From: Sue Howell
Sent: 29 August 2017 16:37
To: Planning.Responses
Cc: Simon Davis
Subject: RE: Planning Consultation on: Y/44/17/OUT

Comment from Greenspace

Site Address: Land at Stakers Farm North End Road Yapton

Description of Works: Outline Planning Application for 70No. residential dwellings including 30% affordable, public open space & associated landscaping. All matters to be reserved apart from Access (access to be achieved via permitted road (reference Y/93/14/OUT). This application is a Departure from the Development plan

PROPOSED SITE PLAN

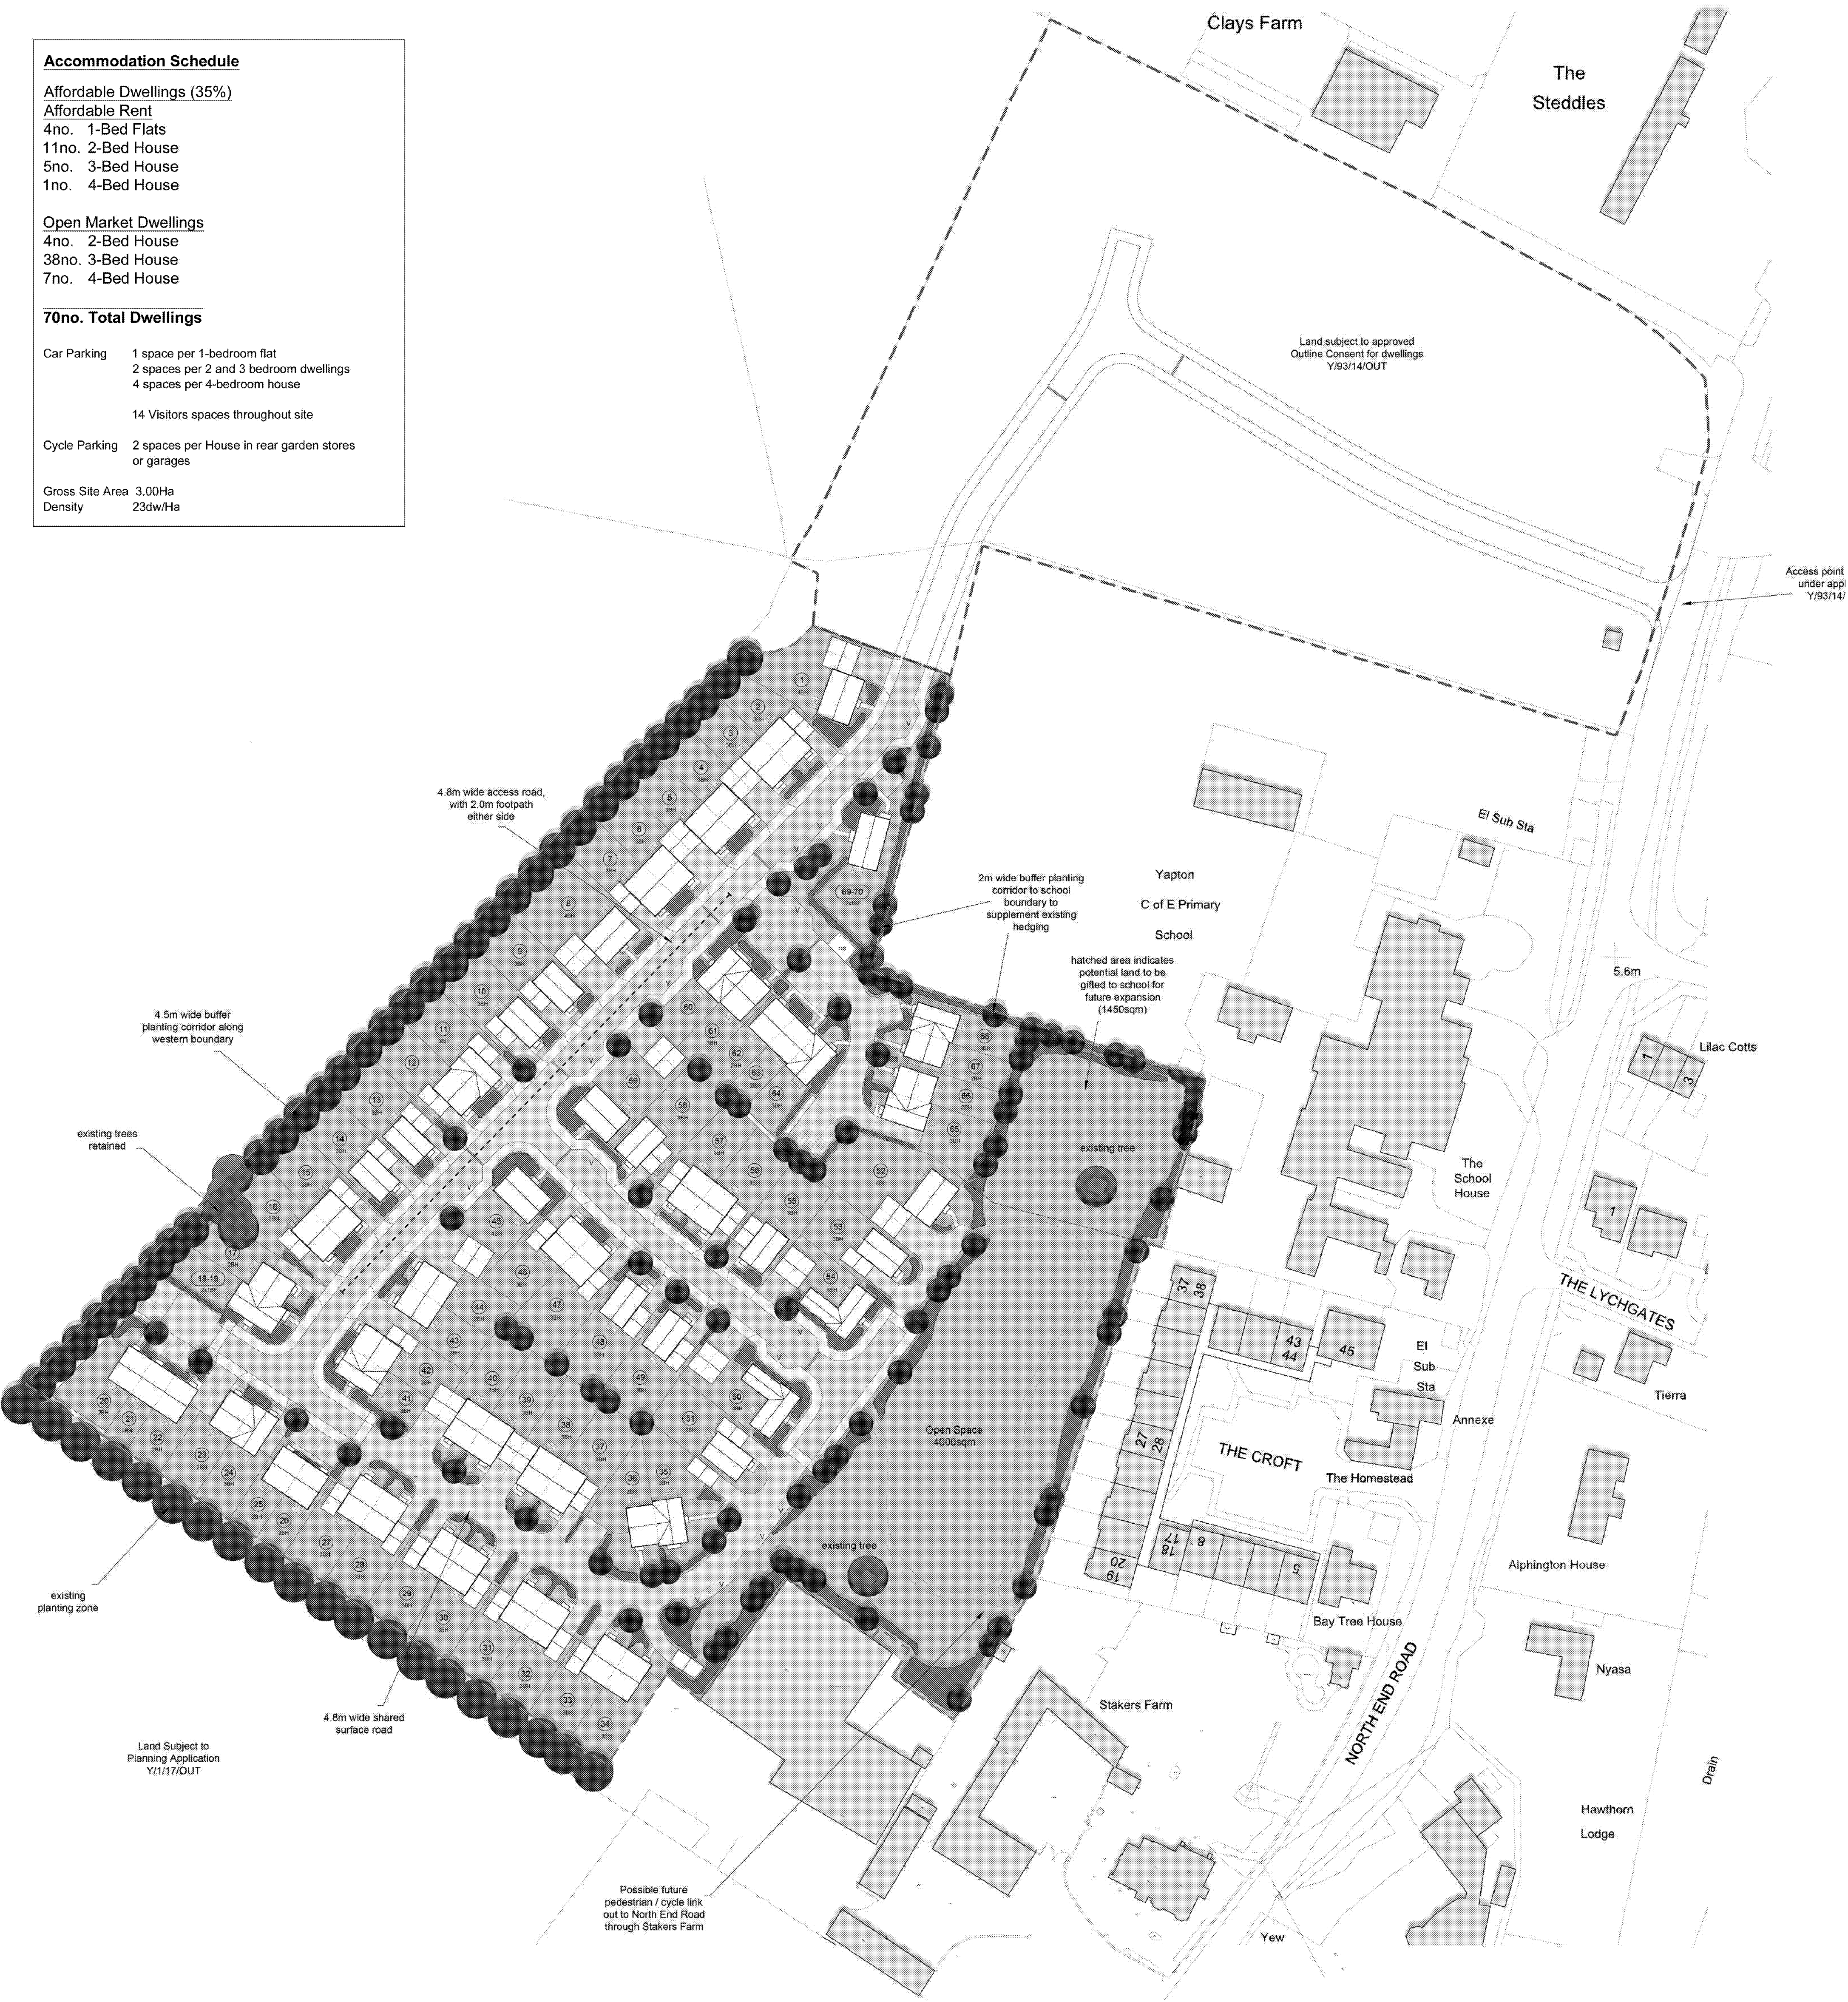
The indicative layout shows a large open space area which creates a usable space and is good to see. Open space in this form will also allow for the establishment of good sized habitat corridor buffers and for the bolstering of existing boundaries.
